**From:** [NectonSubstationAction Messenger](#)  
**To:** [Norfolk Boreas](#)  
**Subject:** Deadline 7 response to applicant's response.  
**Date:** 08 March 2020 08:44:48

**From:** [NectonSubstationAction Messenger](#)  
**To:** [Norfolk Boreas](#)  
**Subject:** Deadline 7  
**Date:** 09 March 2020 16:29:56

2.9.3.4 The Applicant 'Existing ground level': Requirement 16(5) and (8): Considering the more detailed contour information provided [REP4014, Appendix 3], to build the required footprints at 'existing ground level' of 73m AOD for Scenario 1 and 72m AOD for Scenario 2, it appears that fill could need to be imported. The project description refers only to grading and removal of excess material, not bringing in fill [APP-218, para 363]. The Assumed Construction Materials and

SCENARIO 1
 Figure: 29.30b
 Viewpoint 8: Chapel Road, Necton

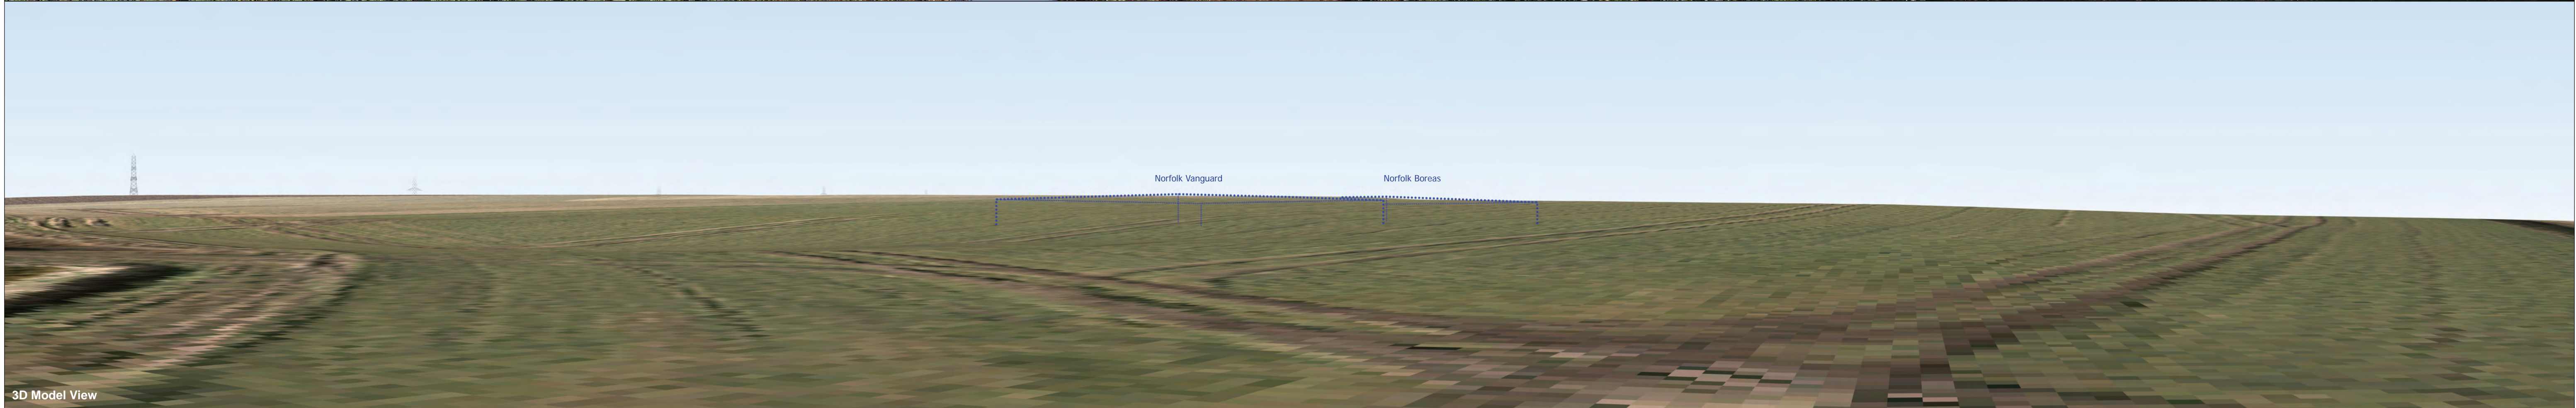
**This is horrendous and shows that the applicant's intention is to raise natural ground levels in order to get a flat surface, instead of lowering them. This means that all their simulations and photomontages are even more inaccurate than we thought. This throws all their mitigation out as far more of the substations will be seen than they had previously disclosed.**
